# CITY OF PORTLAND, MAINE

## PLANNING BOARD

Project Name: Townhouses Units and Hotel/Restaurant  
Address: 749 Congress Street  
Applicant: Denovo, LLC  
Planner: Shukria Wiar

Project ID: 2016-040  
CBL: 047 A020001

C1.1

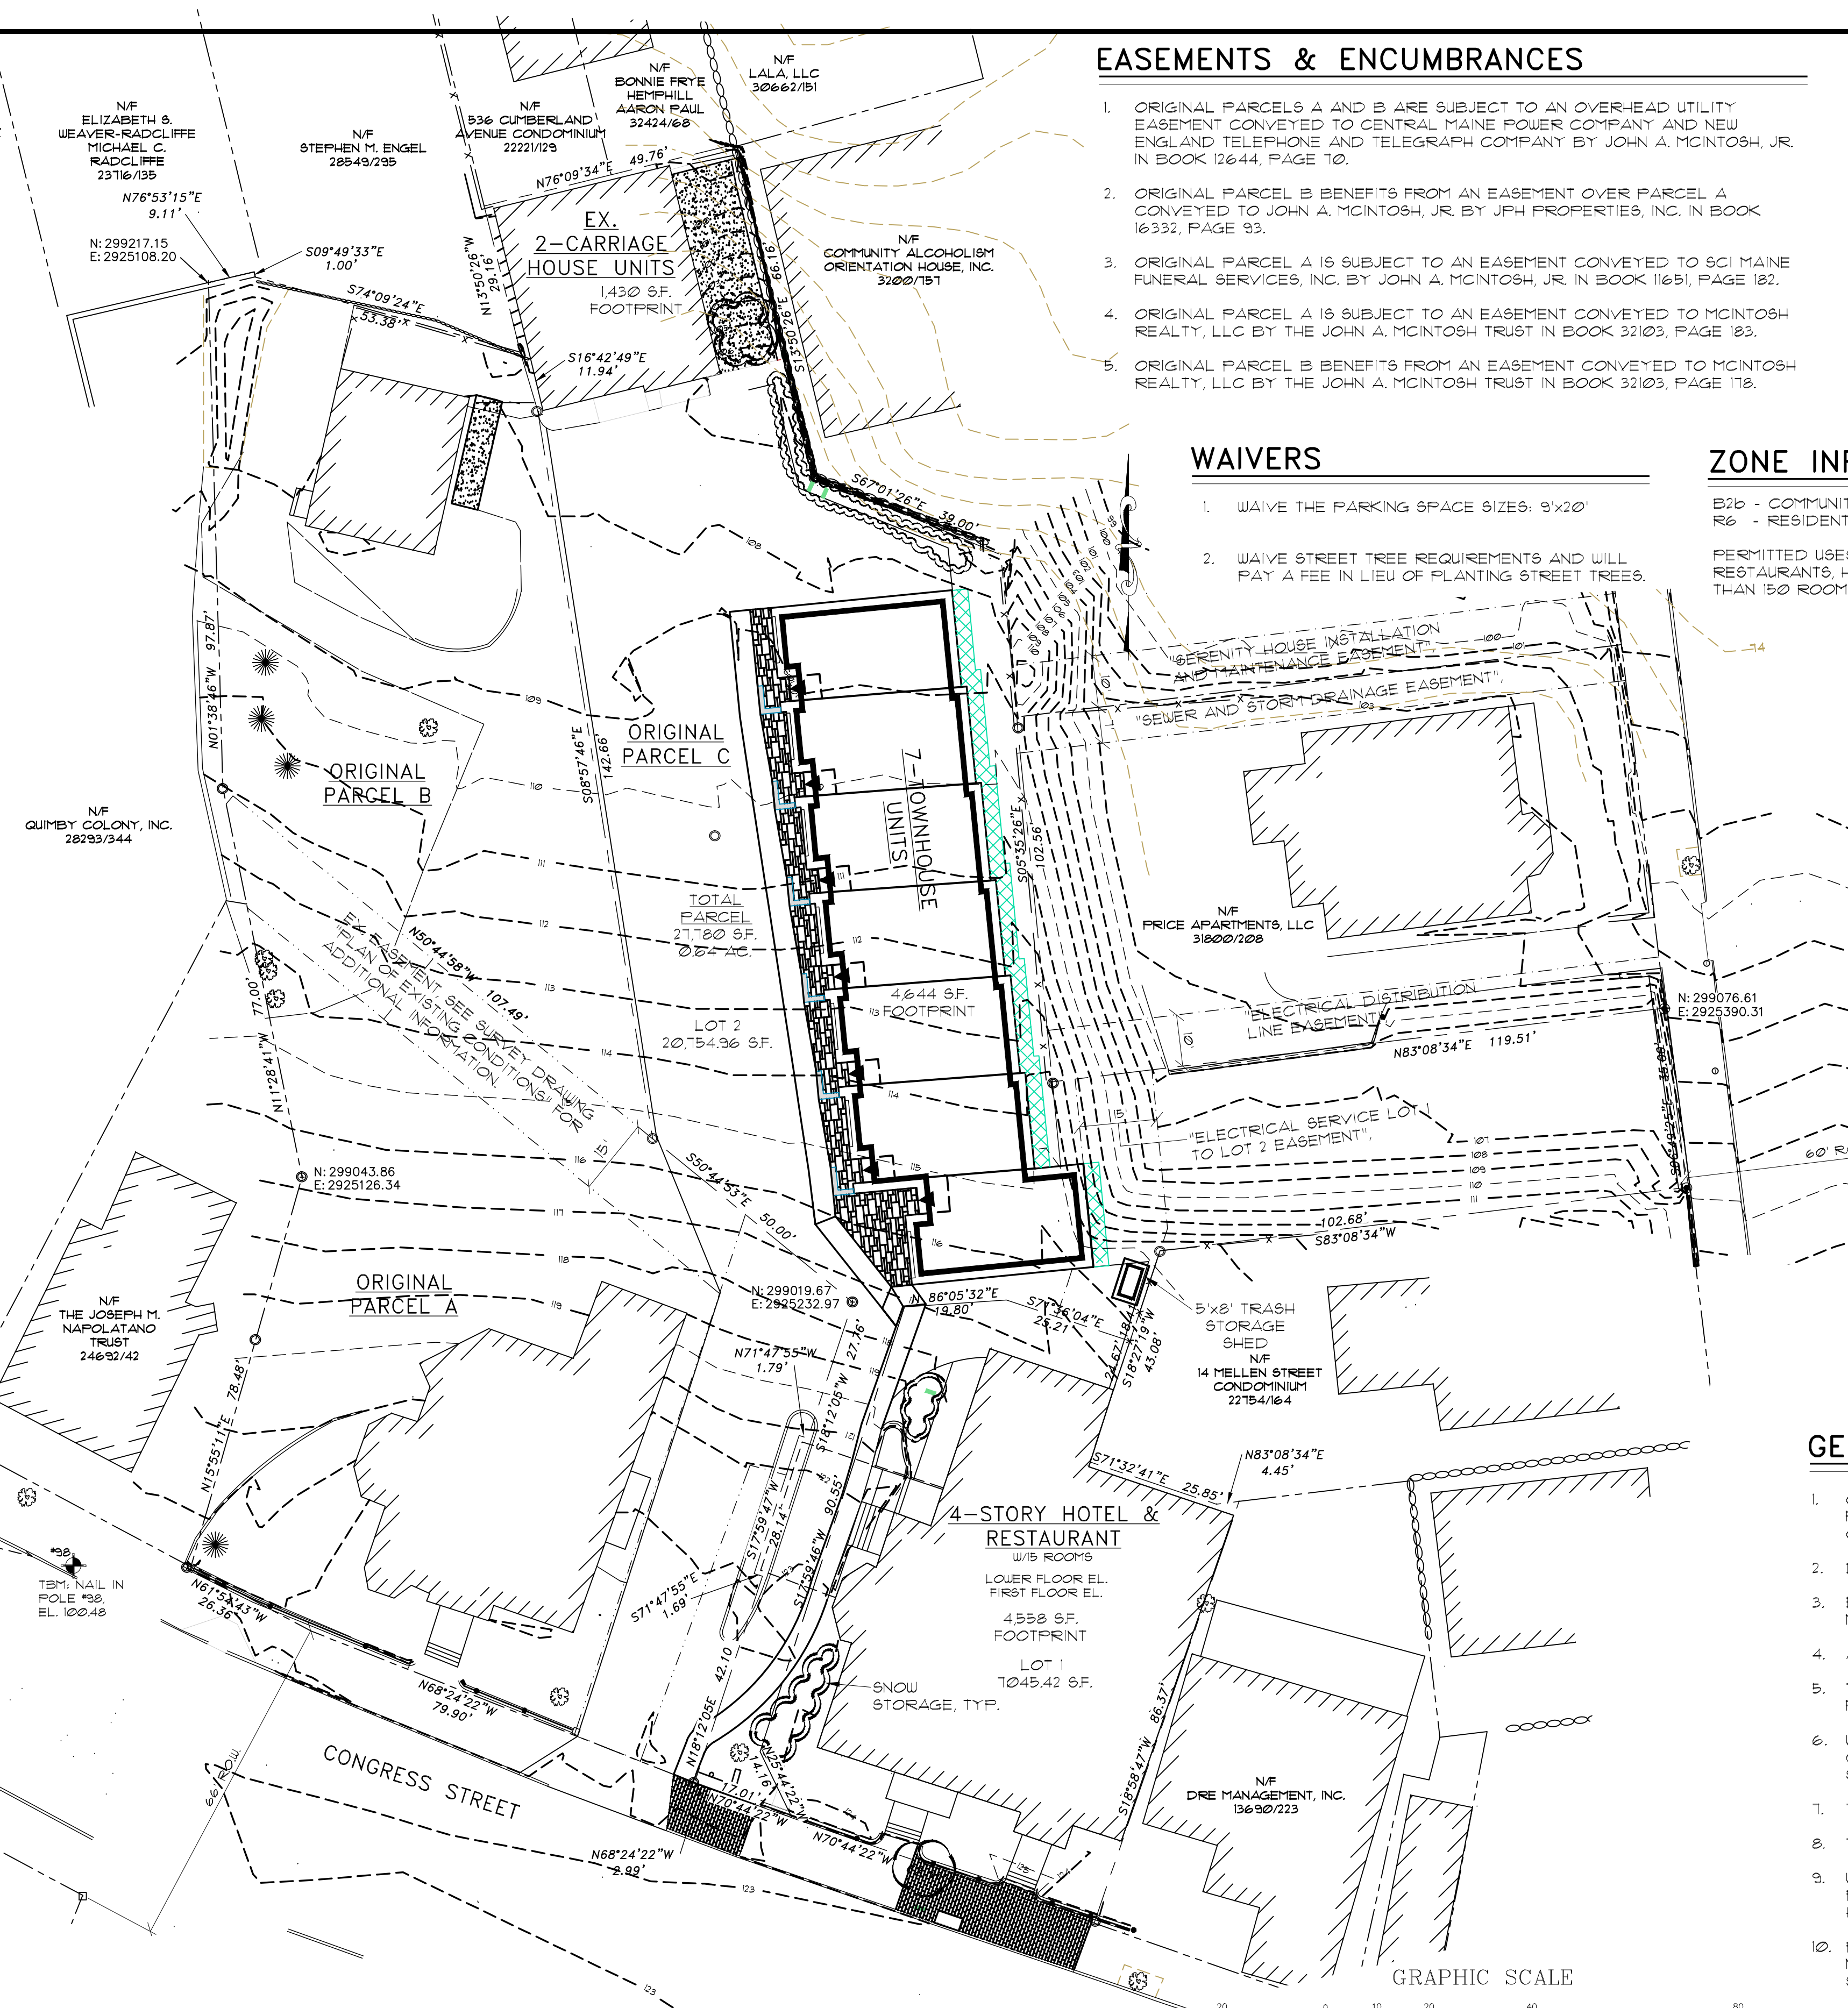
1. The plat shall reflect any easements that relate to the subdivision plan, including the access and utilities easements, to be reviewed and approved by Corporation Counsel prior to the issuance of certificate of occupancy; and

There are instances of text conflicting with hatch patterns. When the Registry of Deeds scans the plans for public viewing via the internet often the text is not legible hatch patterns. The plat will have to be prepared so this does not happen.

Drawing file: Zoning / Plat.pdf

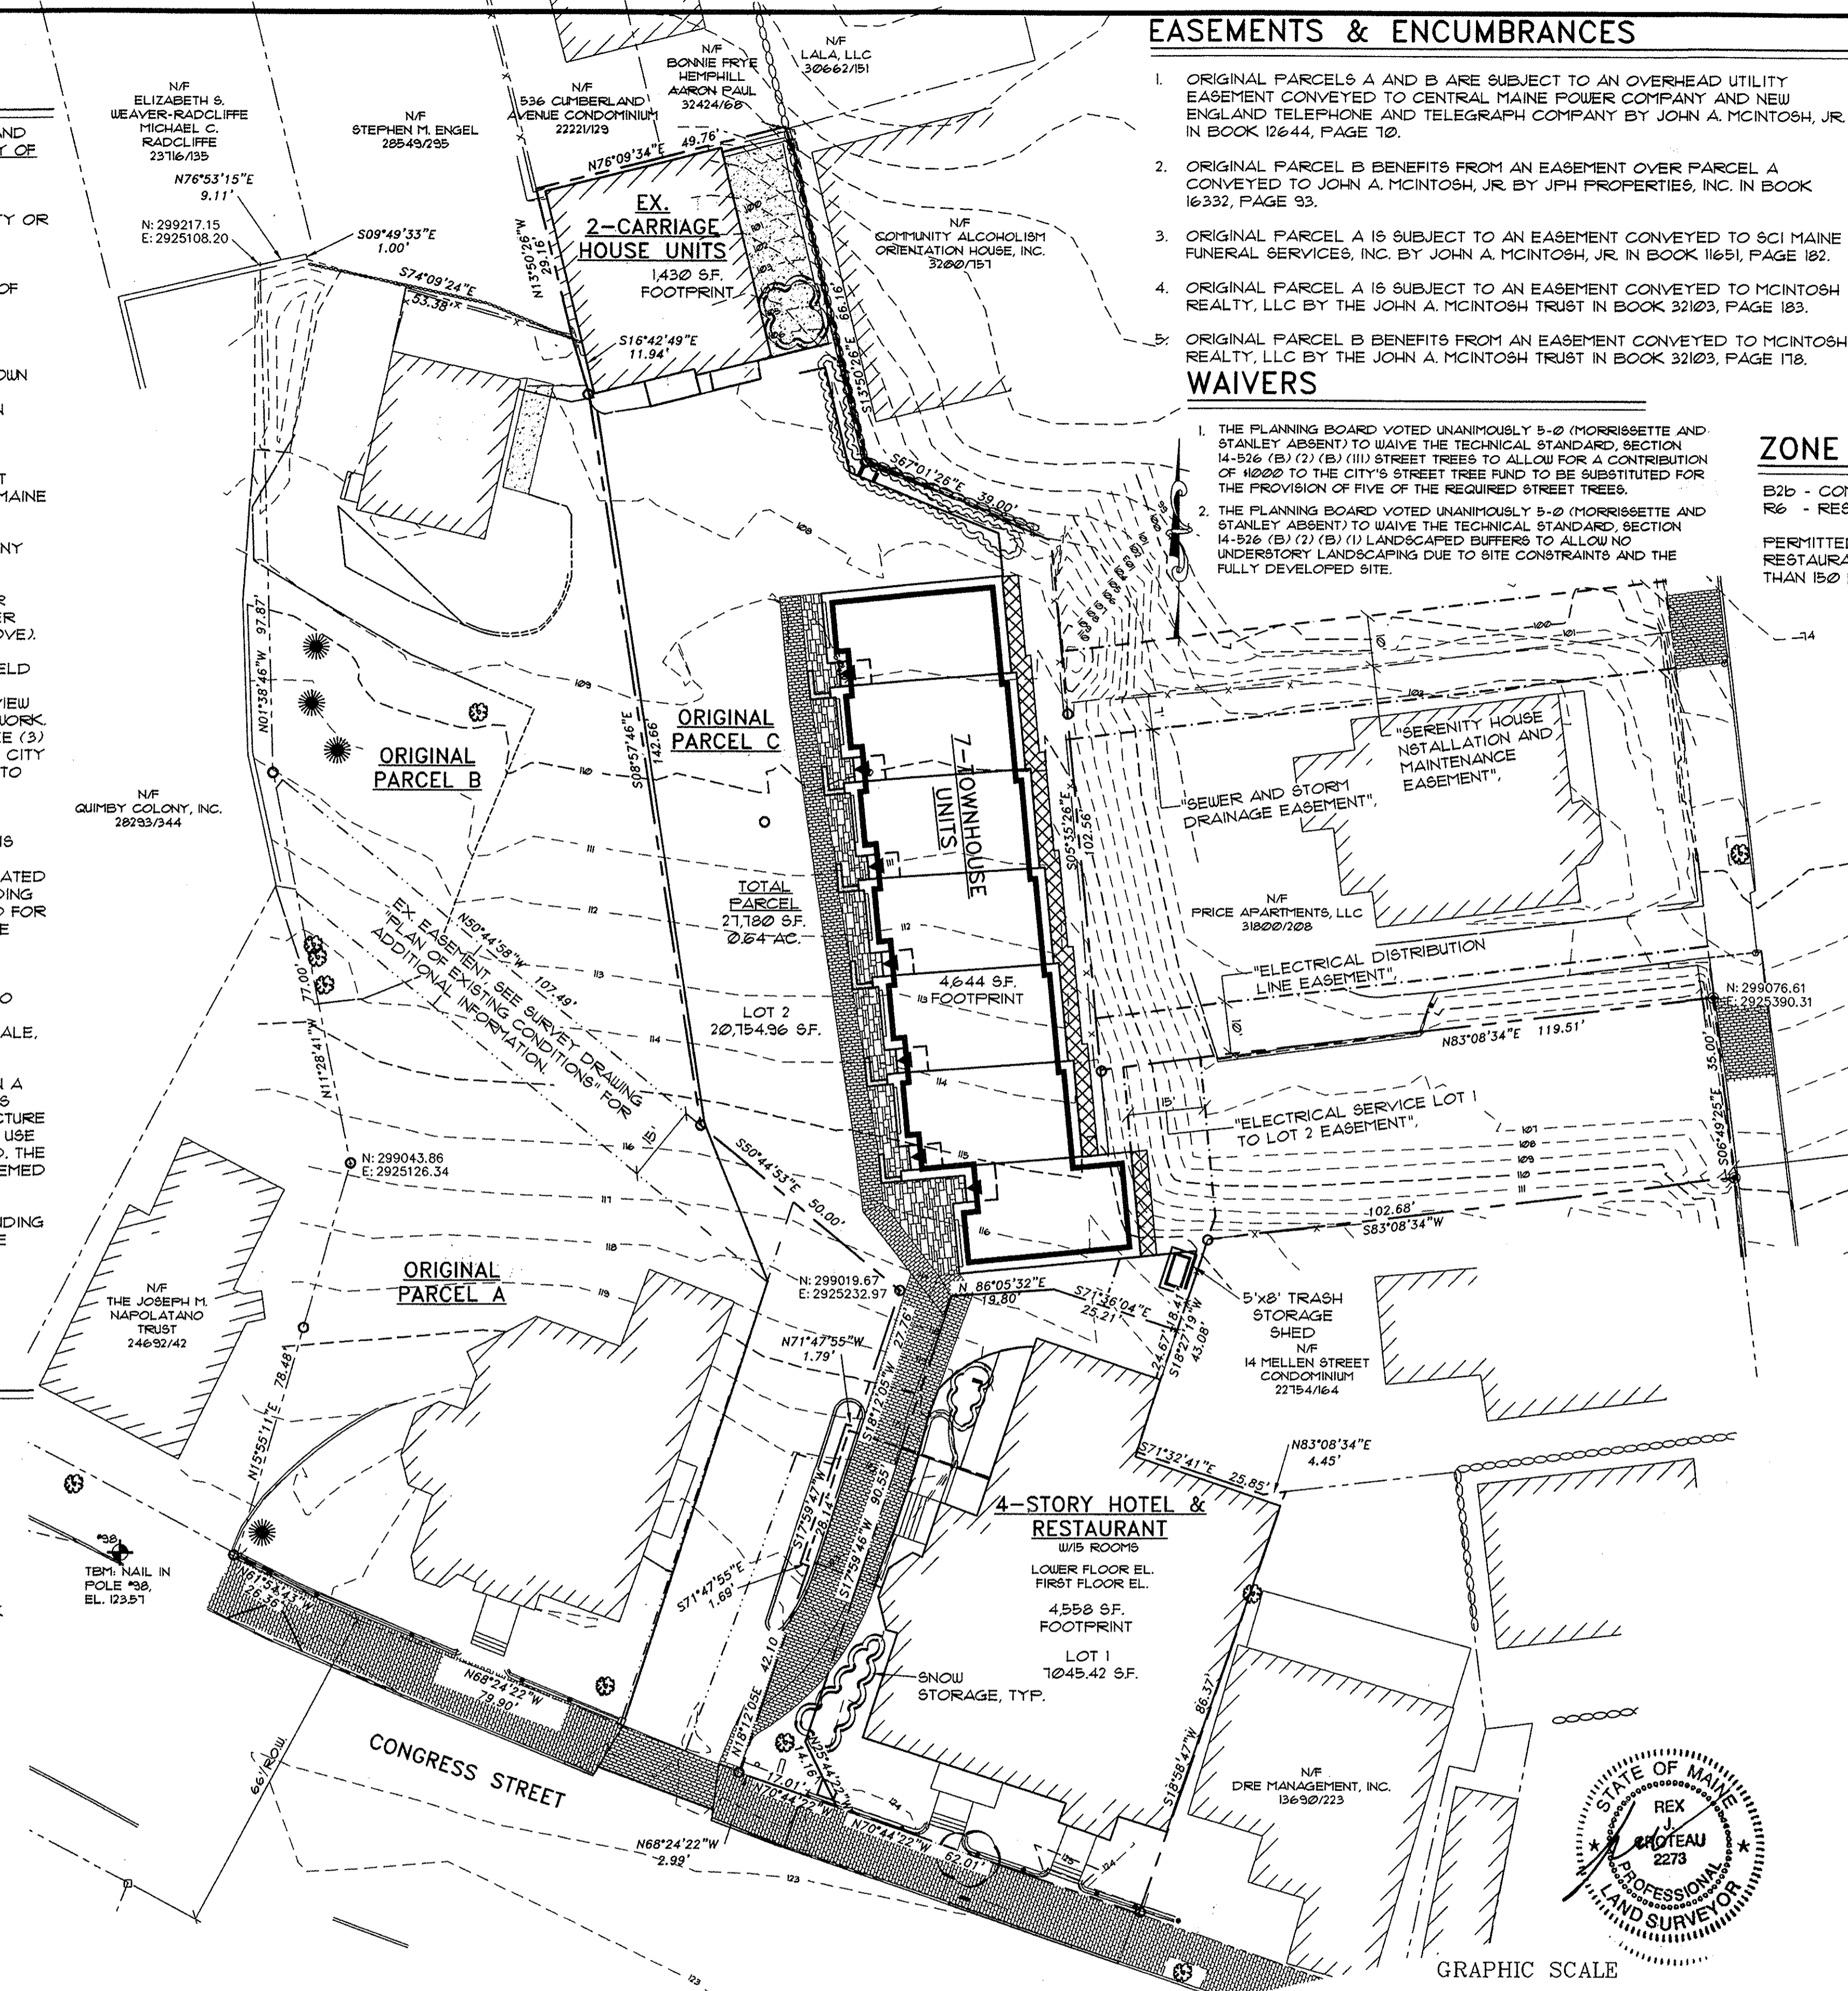
1. The Fire Department has requested that the area between the proposed townhouse building and the hotel building shall be striped and/or marked as the designated "Fire Lane" and shall remain open for emergency uses at all time. This shall be shown on the final site plan; and

3. The proposed bicycle racks shall be relocated to the entrance of the hotel and restaurant building and shall be shown of the final site plan; and
4. The construction management plan shall be revised to show the sidewalk closure detail plan during construction, which shall be reviewed and approved by the Department of Public Works and Planning Authority prior to the issuance of a building permit; and

6. Adequate stabilization (i.e. rip rap) shall be provided at the end of stormdrain pipe at the northern end of the hotel building; and
7. The driveway apron on Congress Street shall be in brick. The Applicant shall modify the plan and provide a detail for brick driveway apron in conformance with the technical standards, prior to the issuance of a building permit; and
